RIBBLE VALLEY BOROUGH COUNCIL

please ask for: JOHN MACHOLC
direct line: 01200 414502
e-mail: john.macholc@ribblevalley.gov.uk
my ref: JM3/2019/1061
your ref:
date: 27 May 2019

RE: The Lancashire Advanced Engineering and Manufacturing Enterprise Zone (Samlesbury) Local Development Order No.2 (2014) (LDO): Prior Notification of Development

Development: Advanced Manufacturing Research Centre (North West) on a development plot at the South East end of the Enterprise Zone.

Drawing No.
832-CPA-ZZ-ZZ-DR-A-2200

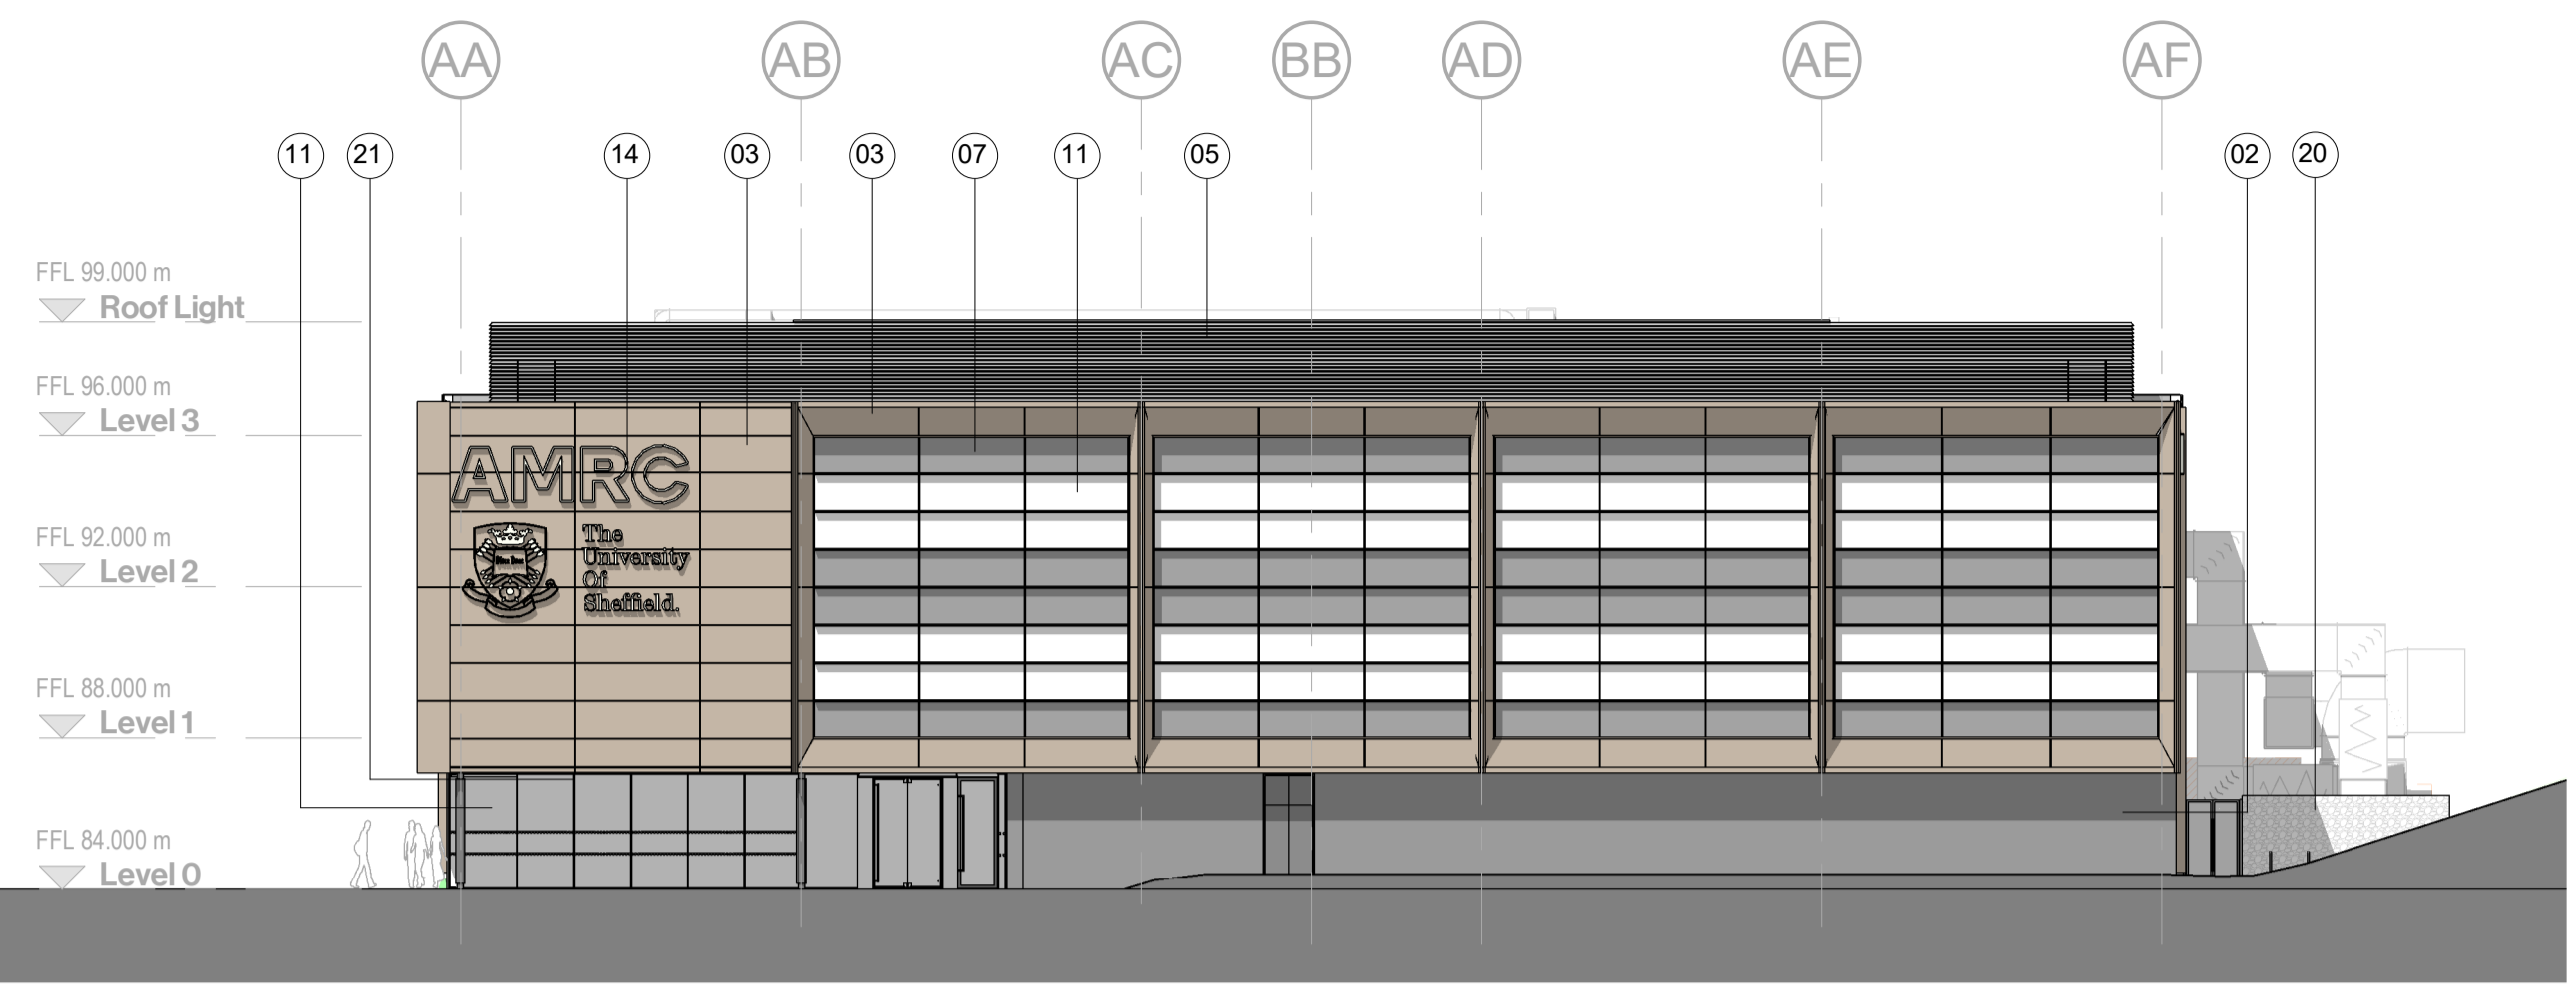
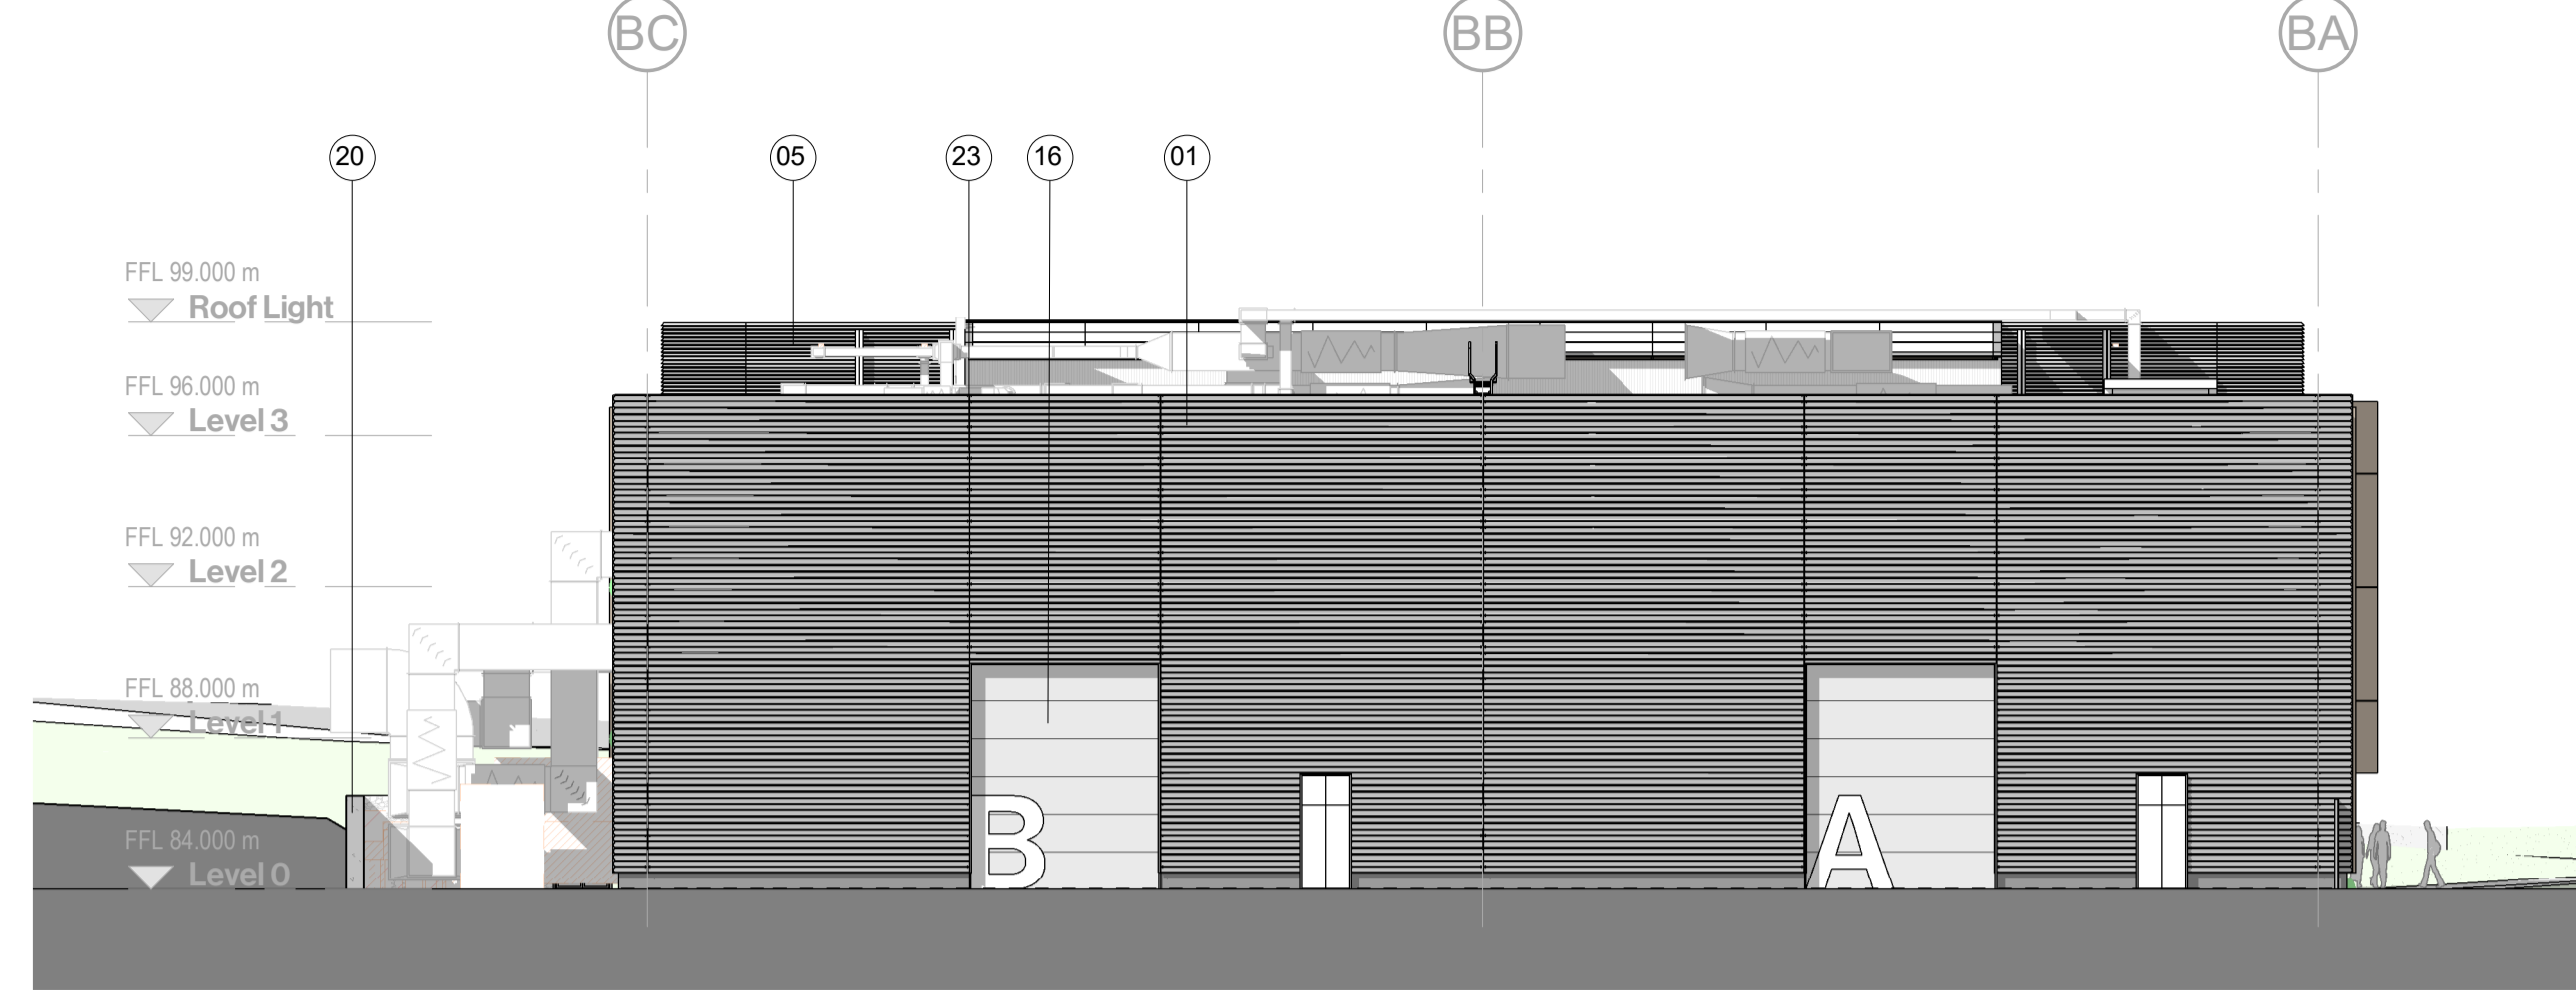
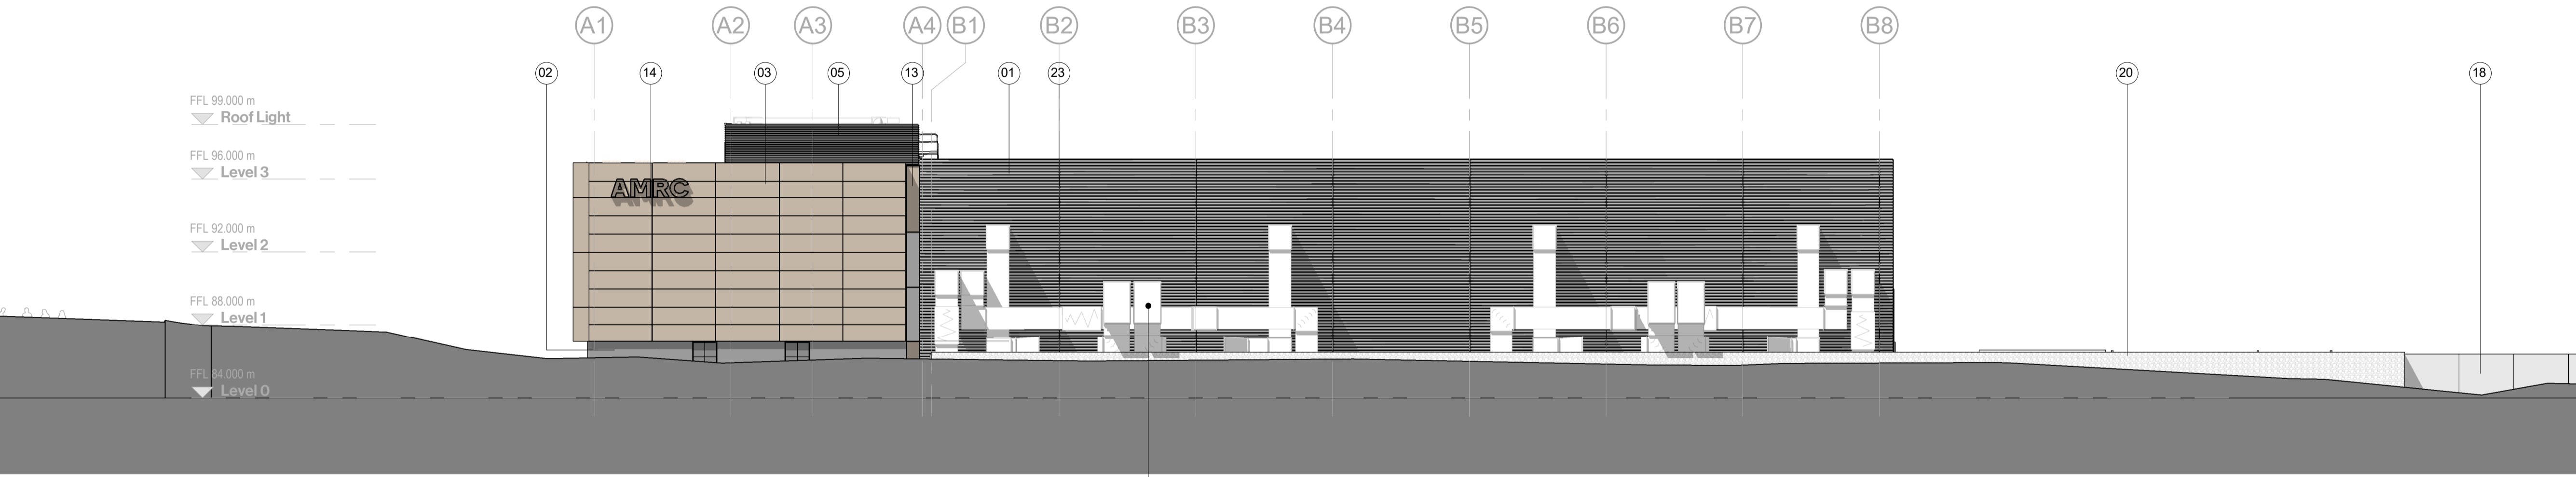
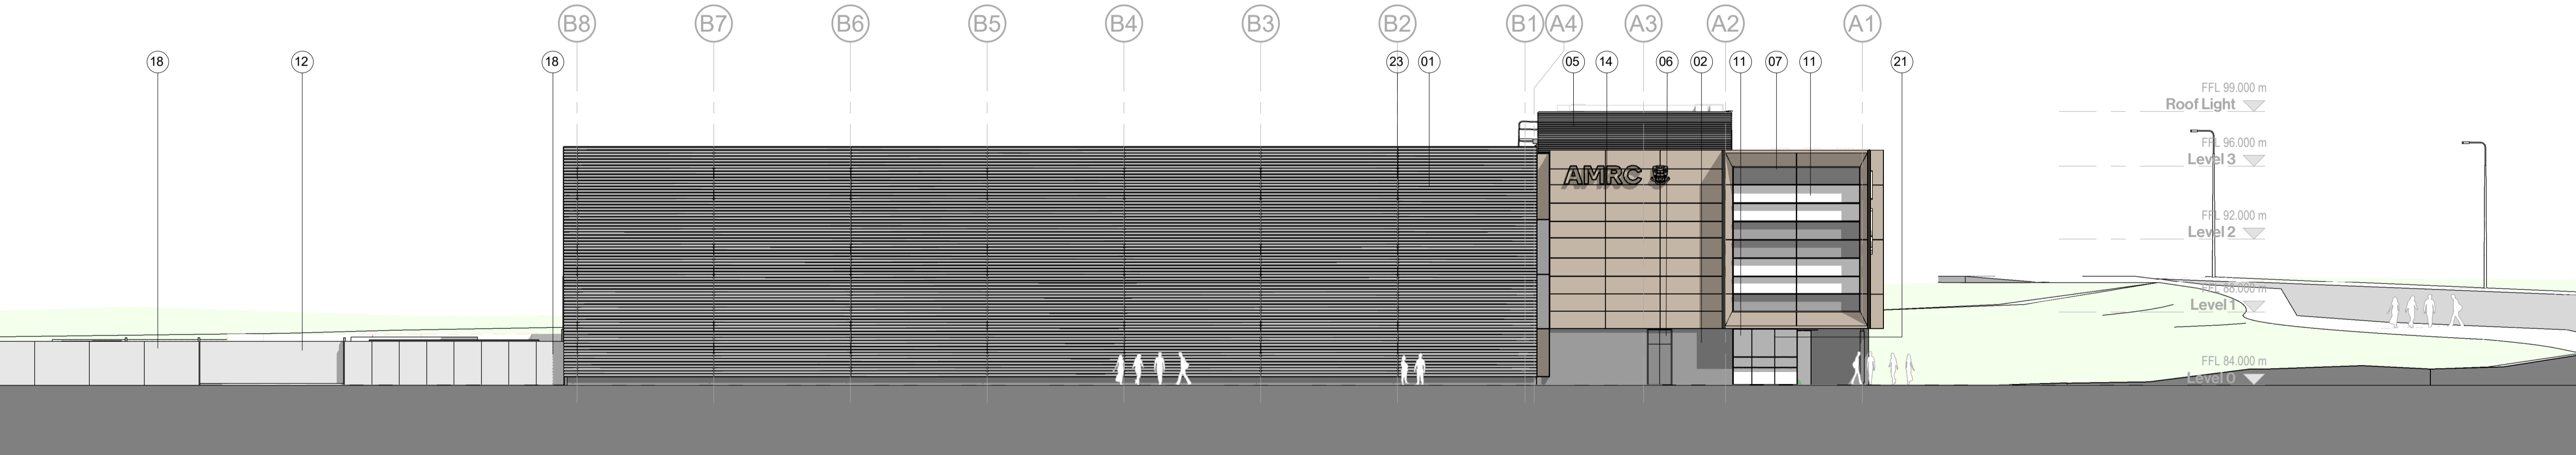
- Vertical articulation retained
- Separation between bays omitted to rationalise design (south elevation)
- Bay projection reduced from 1500mm to 750mm (south elevation)
- Slot windows omitted from workshop to create a 'black box' controlled space (south, west and east elevations)
- Vertical fixing fins to break down the mass of elevation (north elevation)
- Glazing bars to be removed from workshop (east and west elevations)
